KITTTITAS COUNTY COMMUNITY DEVELOPMENT SERVICES

February 10, 2021

Subject: Riste Short Plat Final (SPF-21-00001) – Staff Review and Request for Additional Information

RISTE SHORT PLAT SP-15-00007

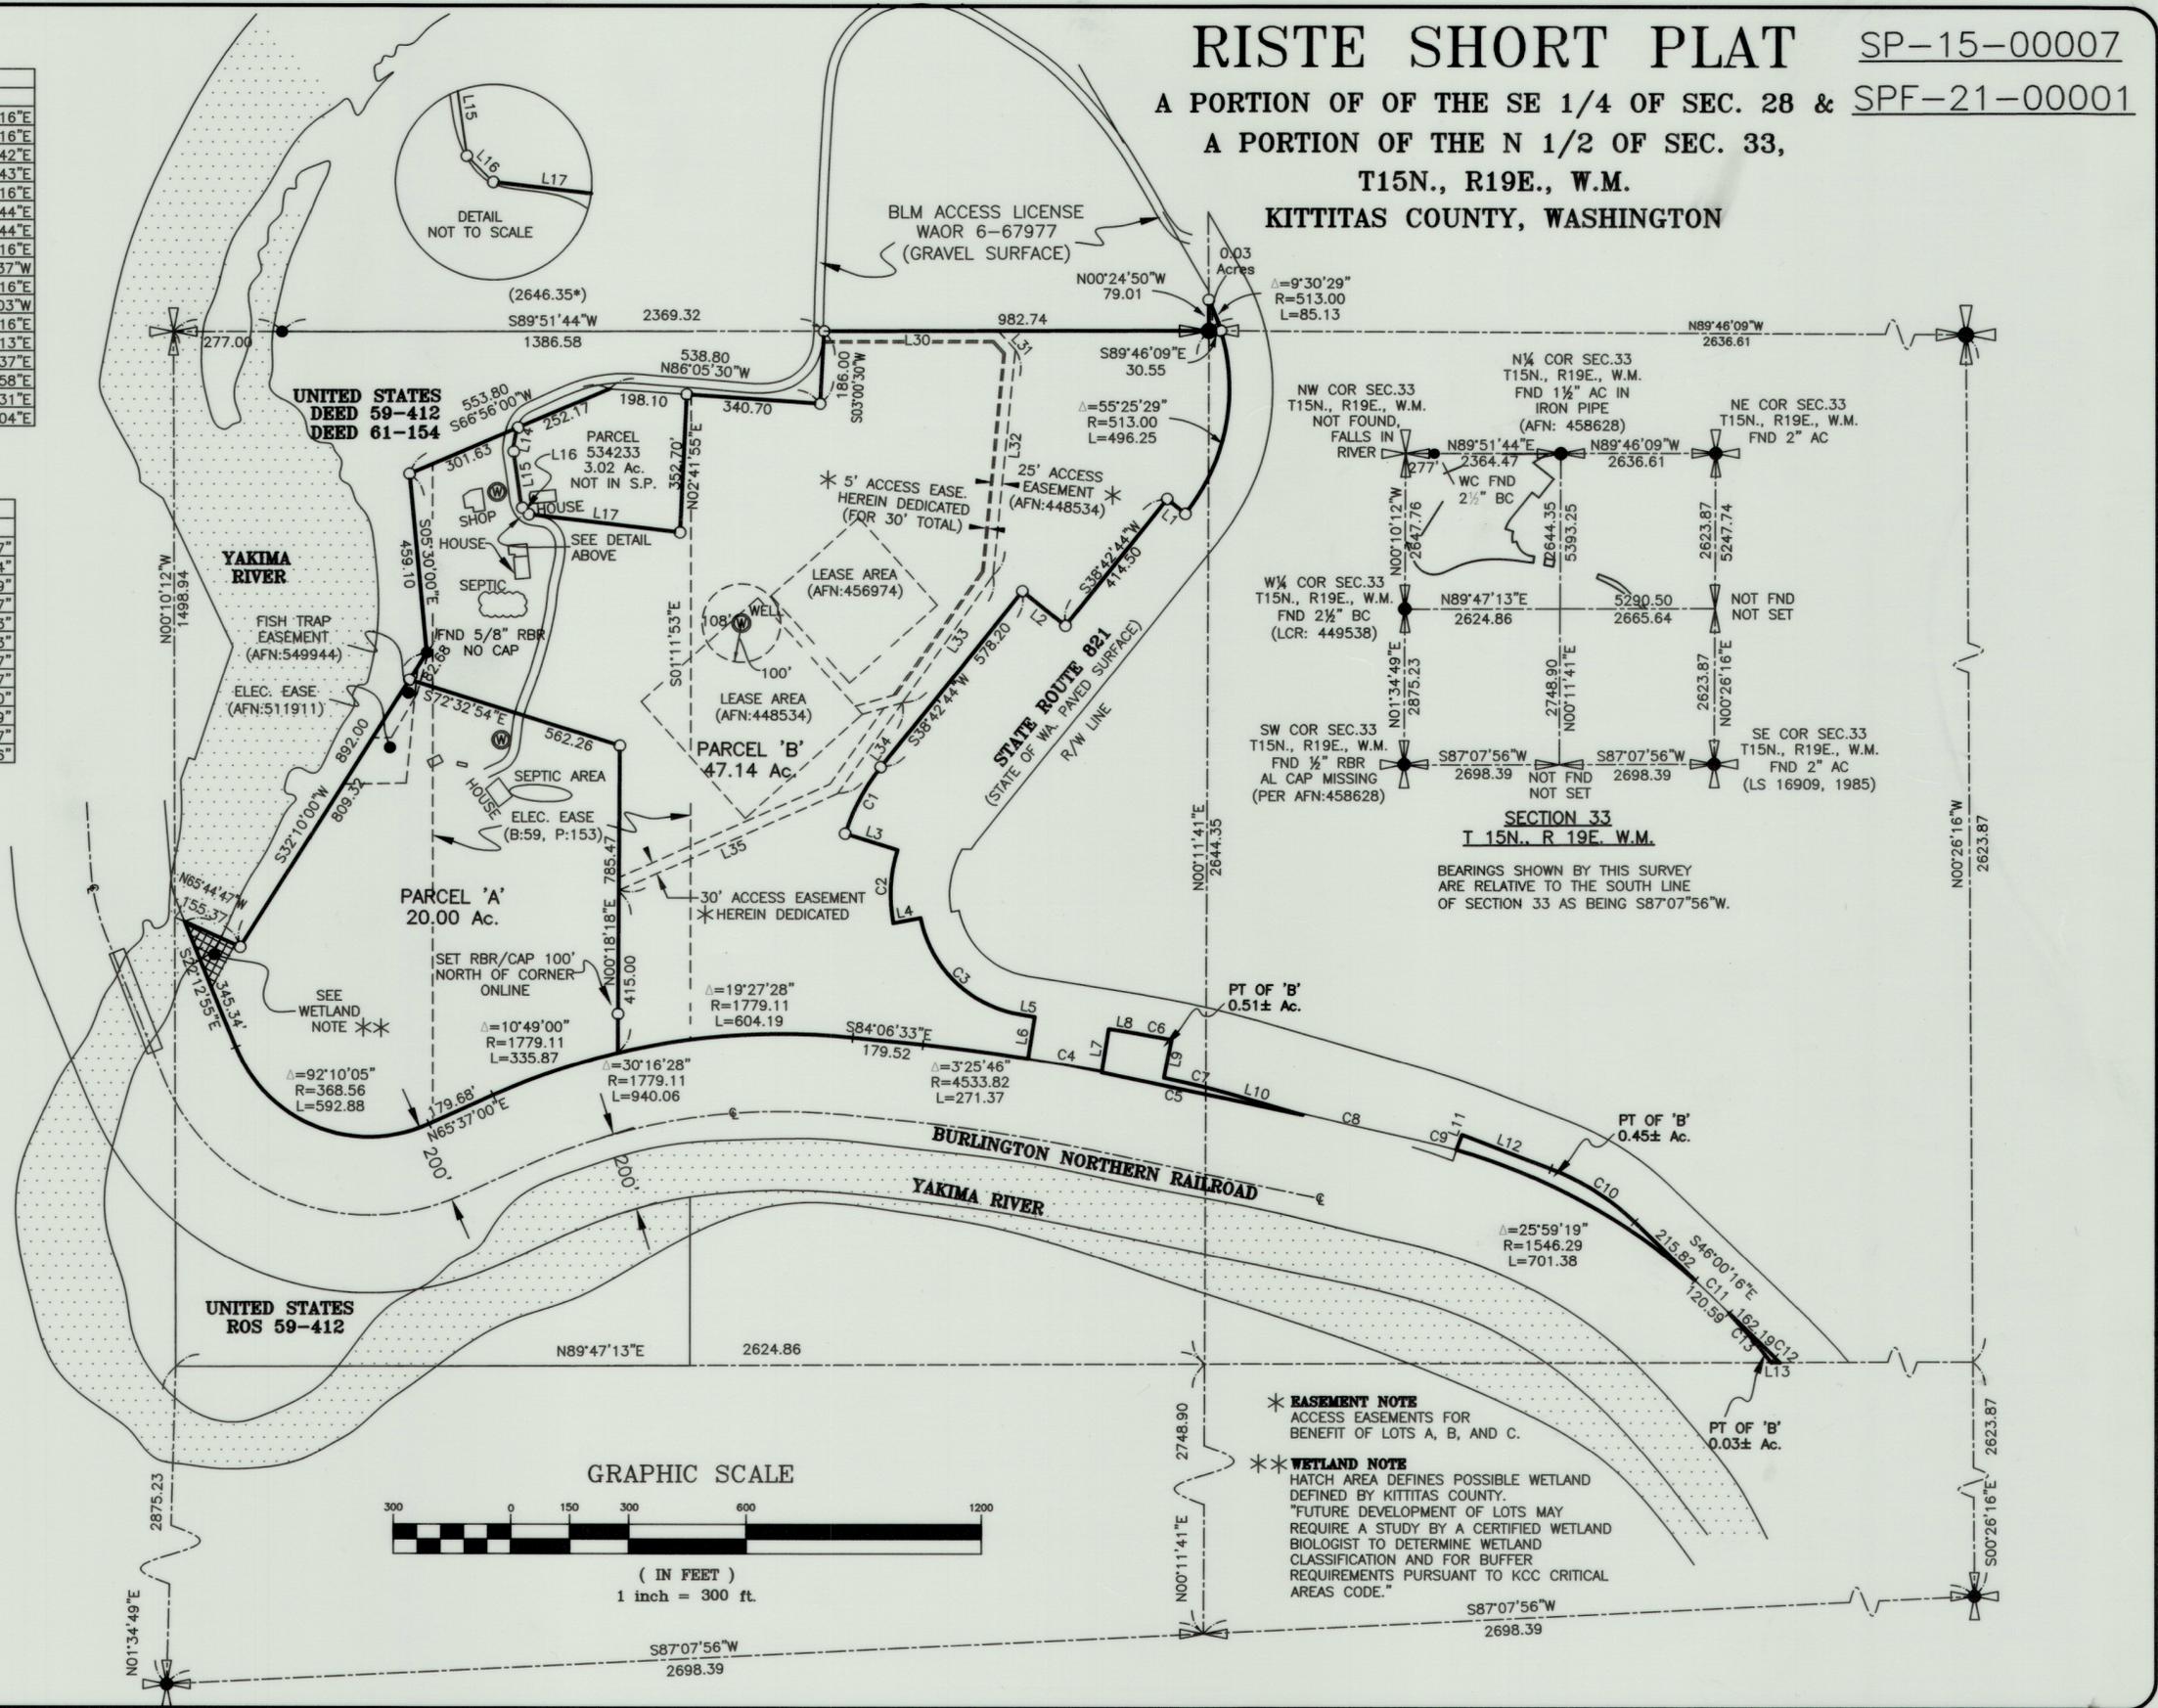
- The final short plat number “SPF-21-00001” shall also be present on the face of the plat and located directly above or below the SP-15-00007 already shown.
